Norfolk Vanguard Offshore Wind Farm

REPRESENTATIONS FOLLOWING DEADLINE 7 SUBMISSIONS

NORTH NORFOLK DISTRICT COUNCIL
(INTERESTED PARTY REF: 20012882)

DEADLINE 8 – 30 MAY 2019

Appendix B – Traffic Management Concept Drawings

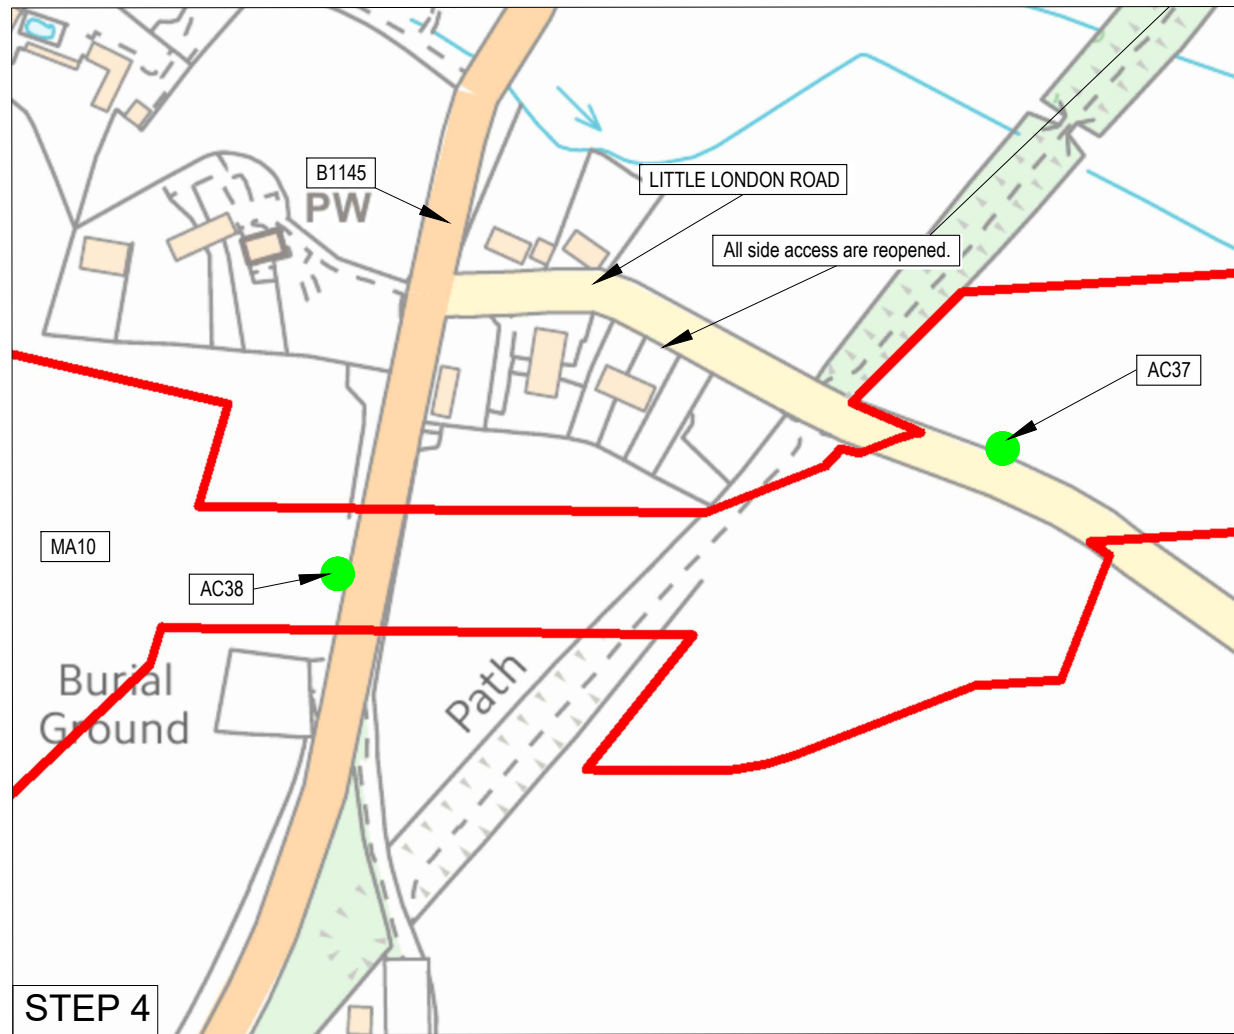
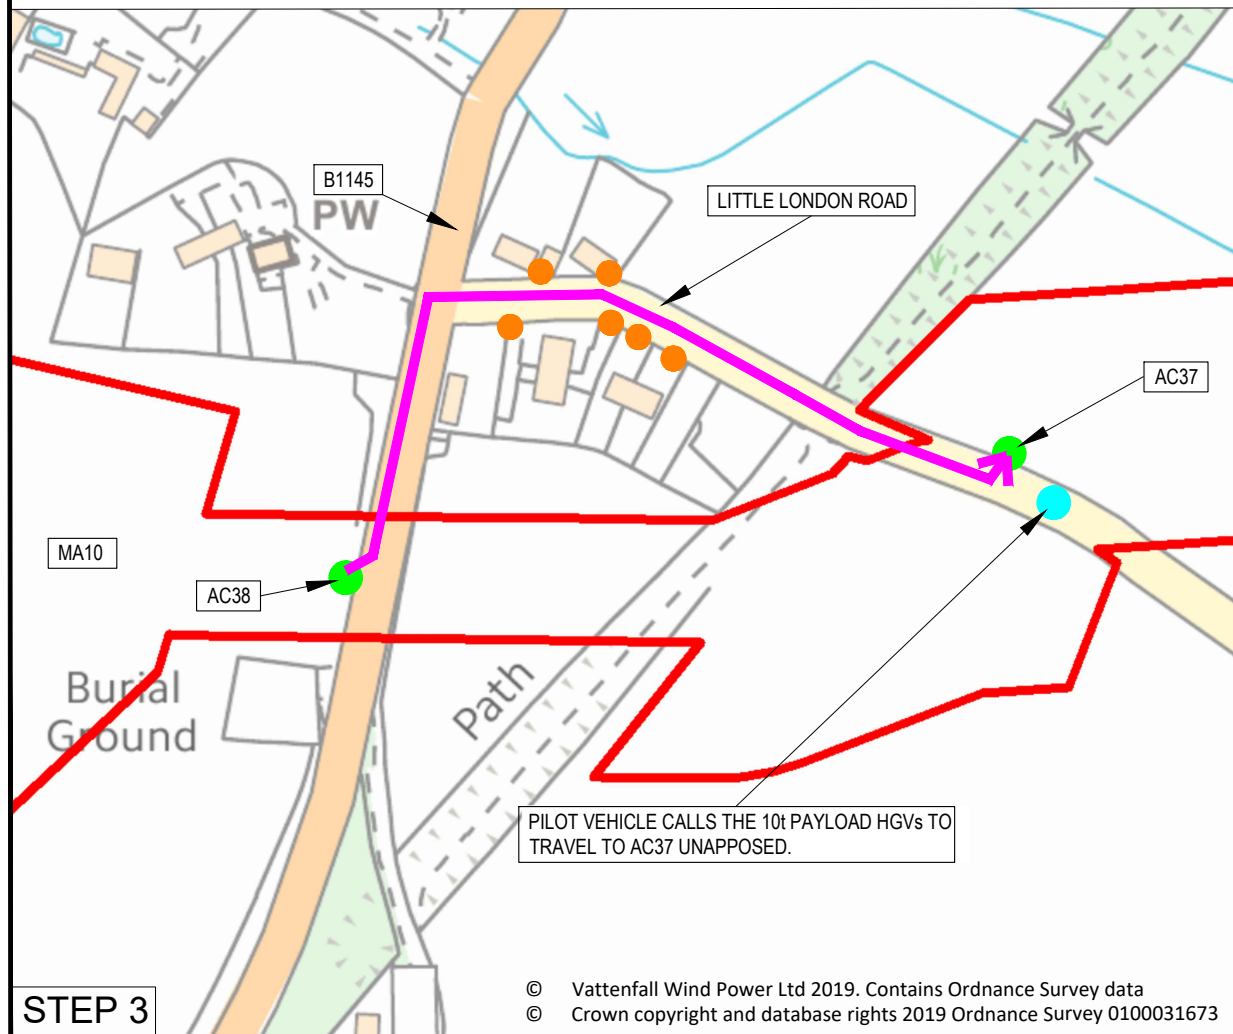
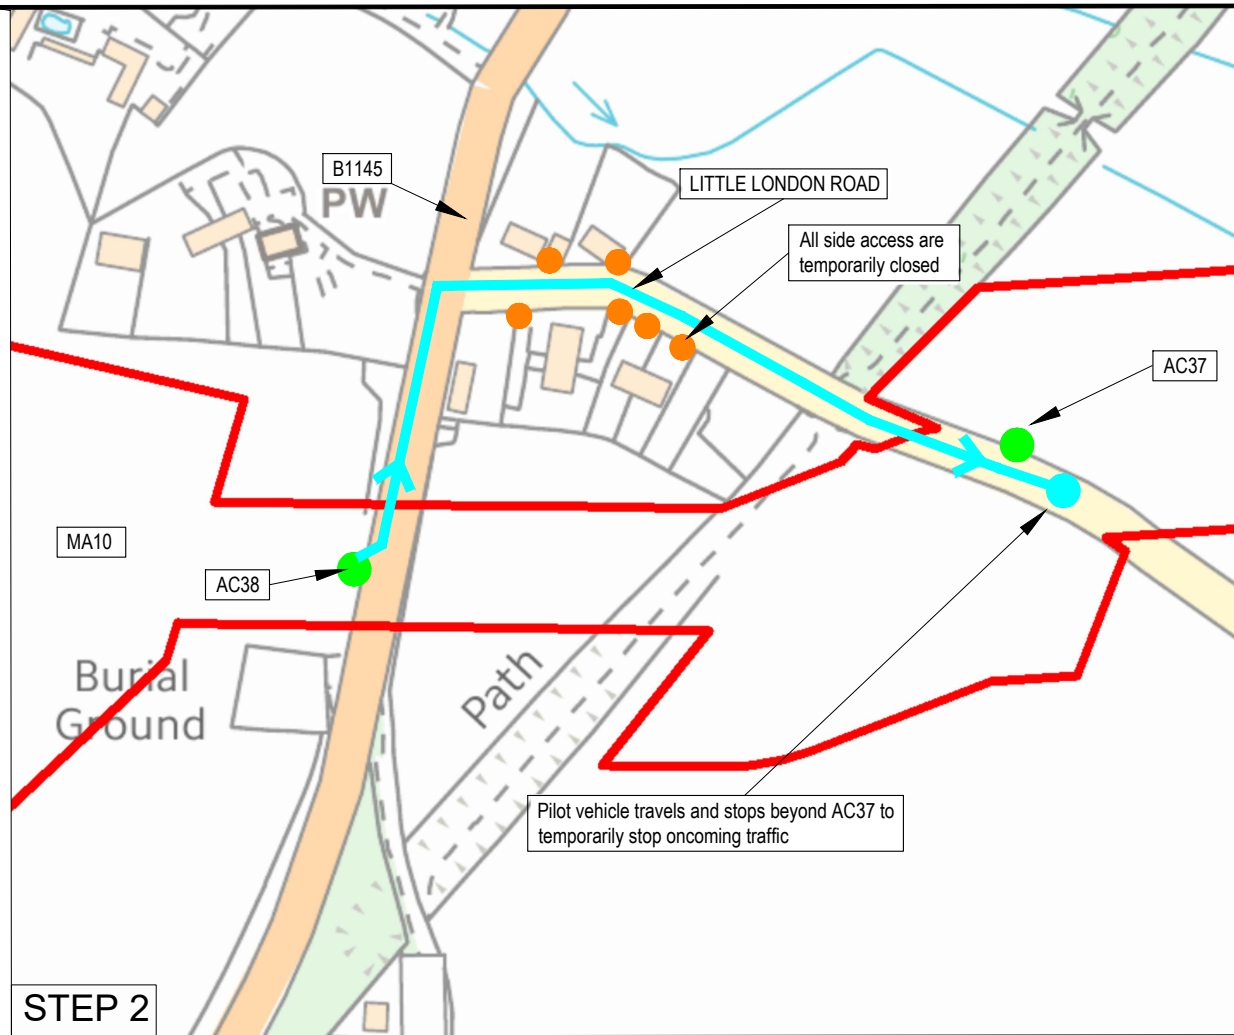
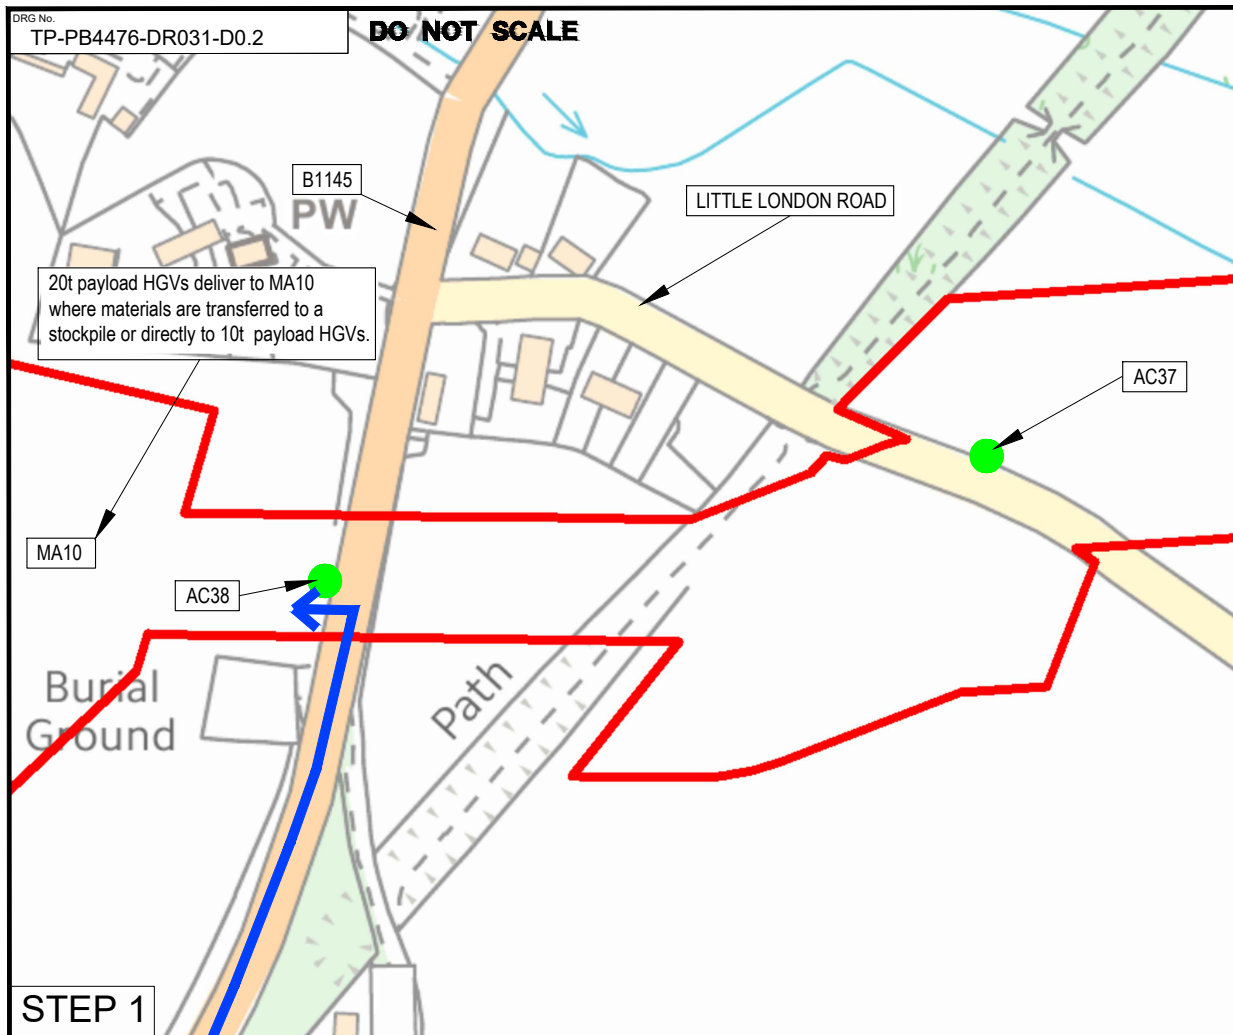
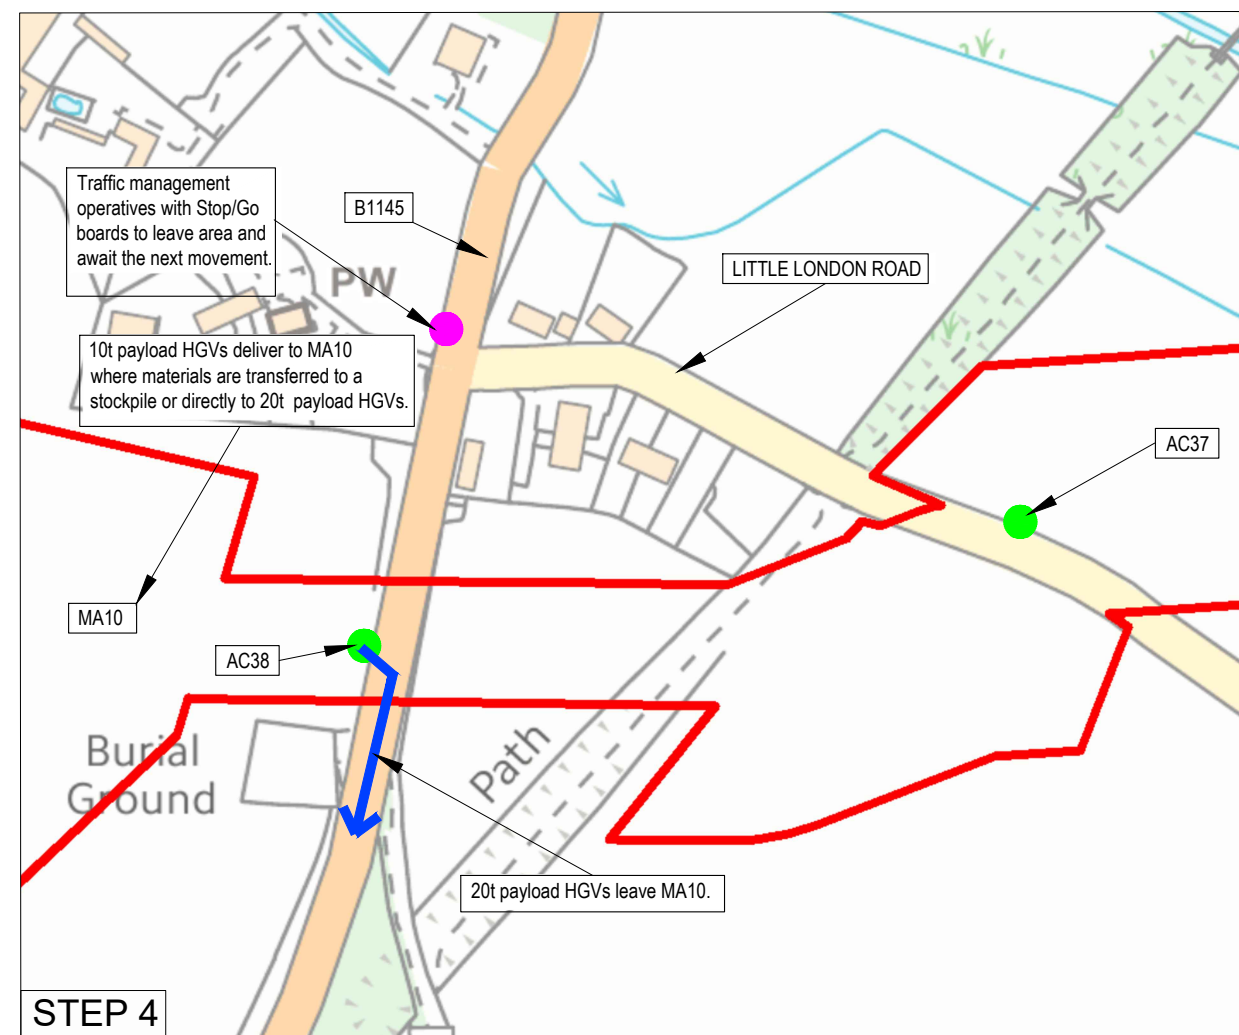
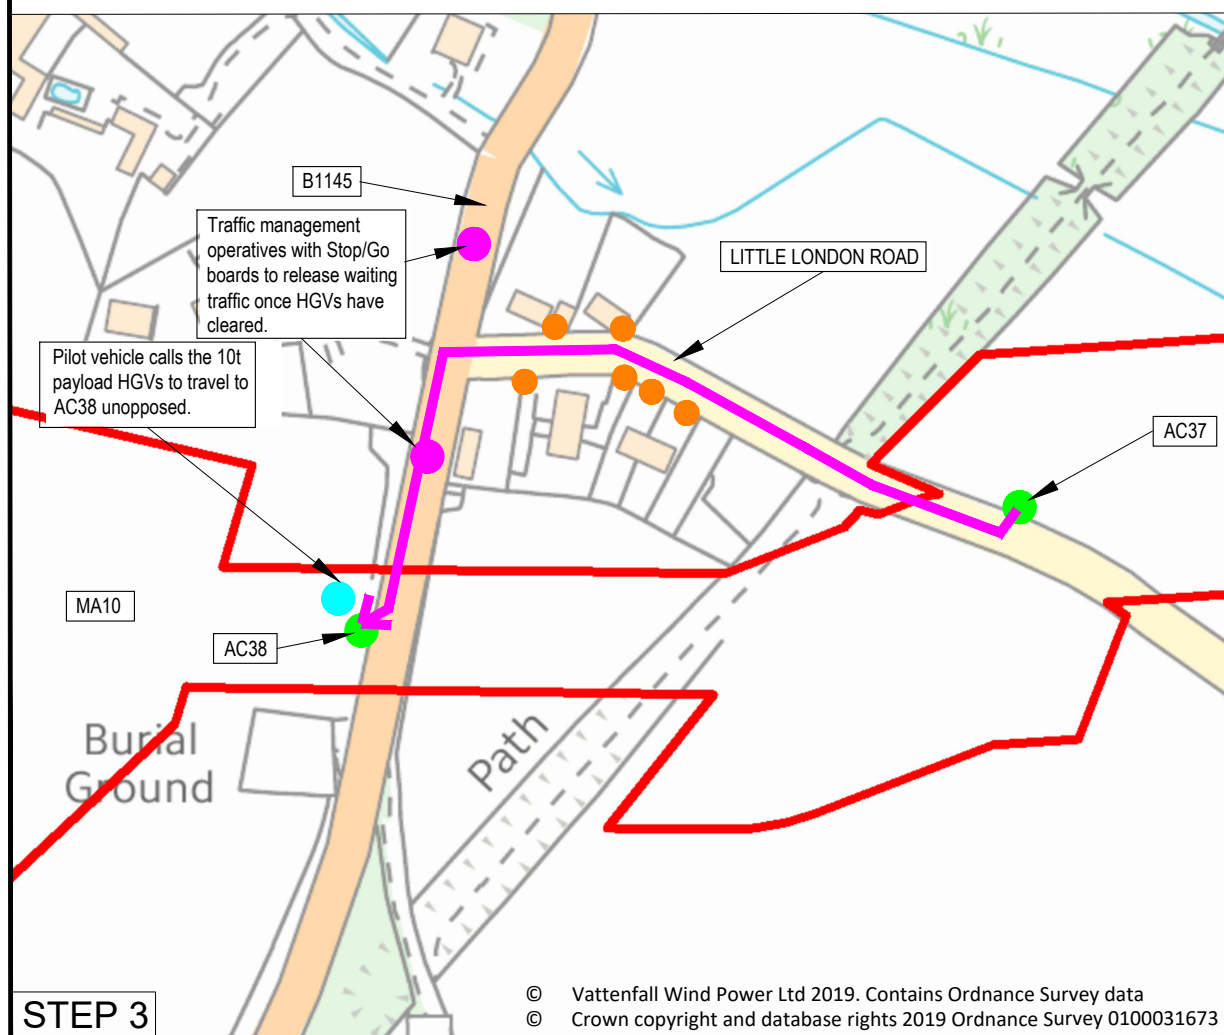
- 5.4. In respect of Stage 2 Duct installation works, the Applicant is proposing use of a Pilot vehicle to accompany 10 tonne HGVs arriving as a platoon from MA10 Mobilisation Area with an estimate of 1 platoon departure and arrival per hour of 3 HGVs. Whilst NNDC are supportive of these control measures, further assurances are needed on a speed limit to be set for the platoon and the hours within which the platoon would operate (NNDC preference would be for compressed hours so as to avoid soon after 7am and close to 7pm).

- 5.6. NNDC would welcome and encourage the Applicant to locate the reception sides of TC 14 and TC 15 to the area which Link 69 serves given the predicted reduction from 144 daily movements to 48 daily movements as referenced in Section 5.1 (Stage 2 - Traffic Demand and Duration) and Table 5.3. This should assist in the reduction of noise and disturbance impacts for residents along Little London Road.
